**Your ref: 3/2023/0118; 8 Hammond Drive, Read BB12 7RE**

Further to your letter dated 22 February 2023, we write to object to the retrospective planning application number 3/2023/0118 and invite the Council to require the development to be constructed in accordance with the approved applications 3/2021/0428 and 3/2021/1074. We would not have agreed to the original applications had the property been constructed in the way that is now being proposed.

East Elevation  
1:100 Scale

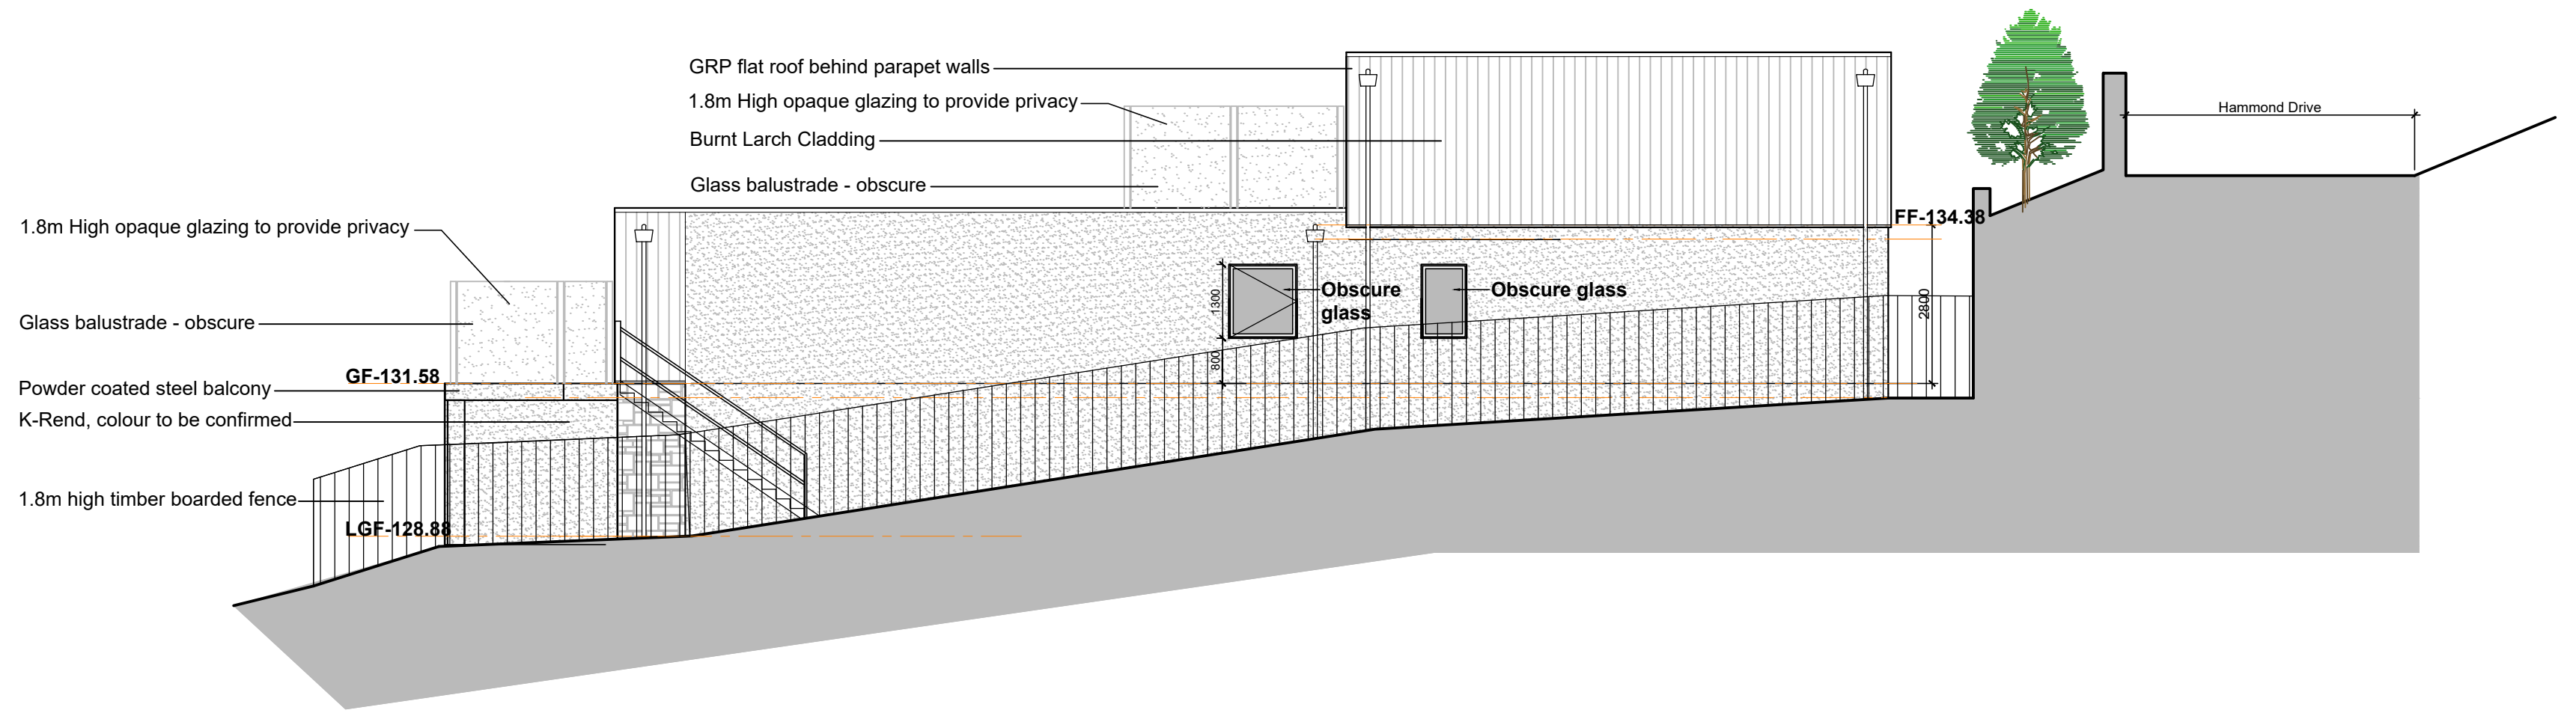
We object to the addition of a second window to the eastern wall. Given the way in which this property is being developed, [REDACTED] that it will be built according to the approved plans. [REDACTED]

The Council's decision dated 3 August 2021 makes clear that the external facing materials detailed on the approved plans shall be used, and no others substituted, to ensure that the materials are appropriate to the locality. The approved application detailed K-Rend to the top floor (which was to be light grey) with burnt larch cladding only to the edges (which is jet black). Whereas the retrospective application seeks approval for black cladding across the entire face of the top floor:

Black cladding across to the top of the eastern elevation would be entirely out of keeping with the materials used in the adjacent buildings and will be an eyesore [REDACTED] who use the public path. It will be easily seen from the road level of Hammond Drive and if retrospective approval is given the property would look like a most unpleasant industrial unit.
